Sent: 15 November 2013 18:10
To: Planning
Subject: Welwyn Hatfield Council Online Planning - Comment

Application Number: N6/2013/1938/MA
Name: Mr H.J. Calderbank
Address: 65 Parkway
Welwyn Garden City
AL8 6JF

Title Proposed Materials

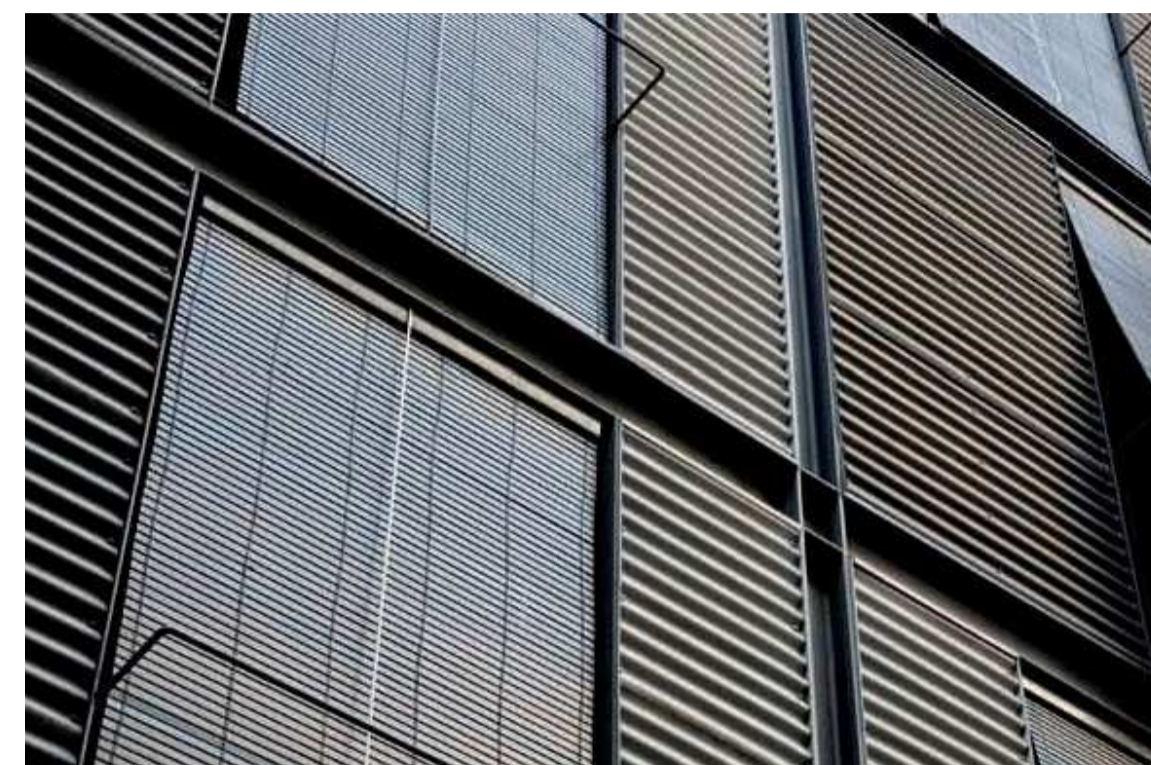
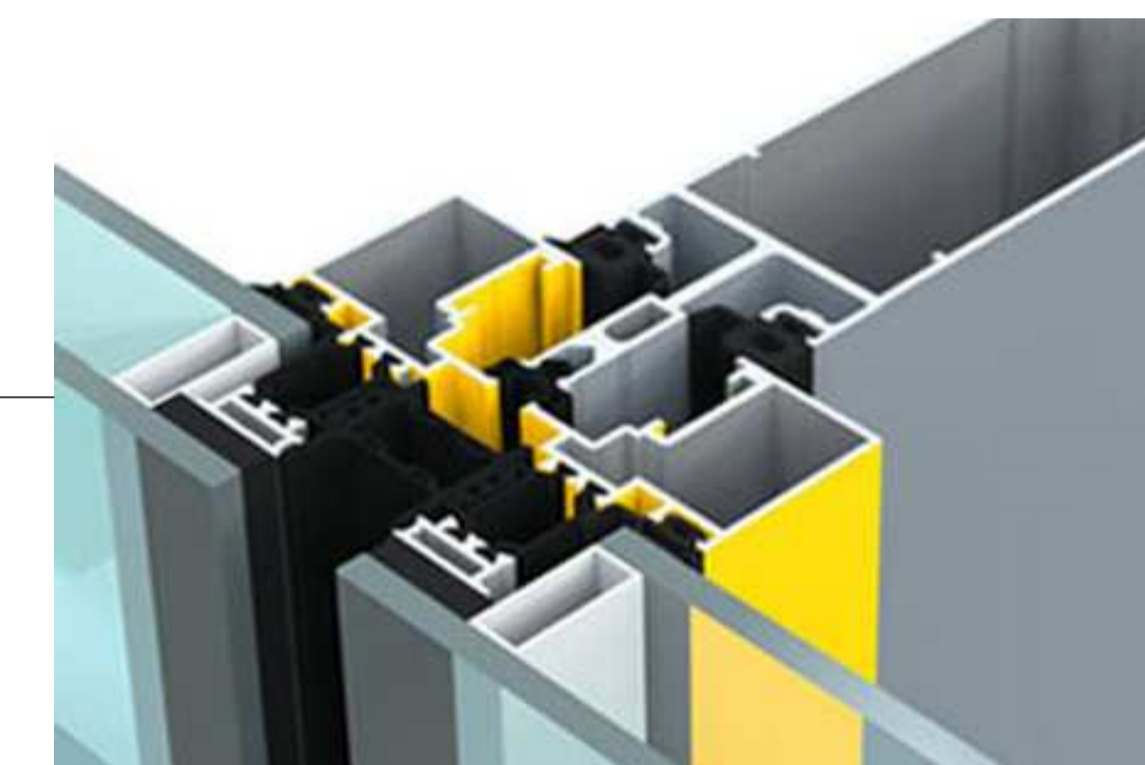
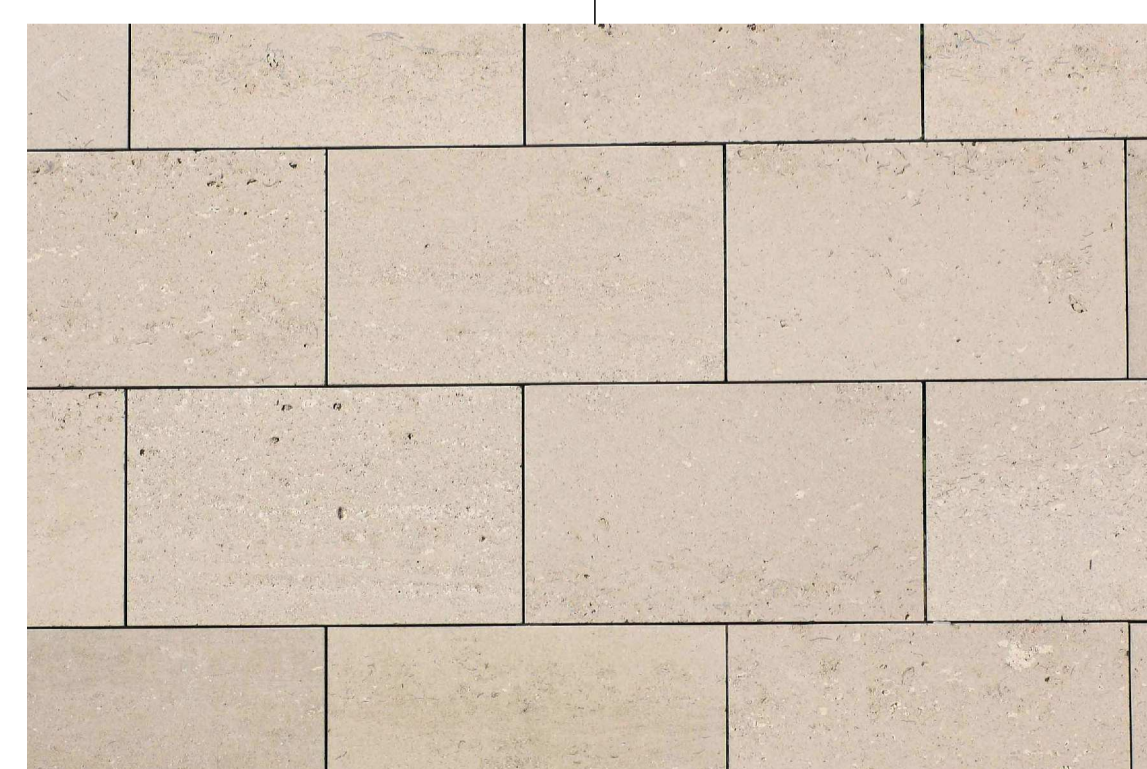
Comment: I have no objection in principle to an infill extension, nor to a sympathetic modern design. But the proposed design is far too 'aggressive', particularly because of the excessively bold 'framing' of the glazed area. It is entirely unsympathetic to the rest of the building and I feel sure that this design would normally be considered by the Council's officers to be in breach of the conservation area rules. I therefore OBJECT to the planning application.
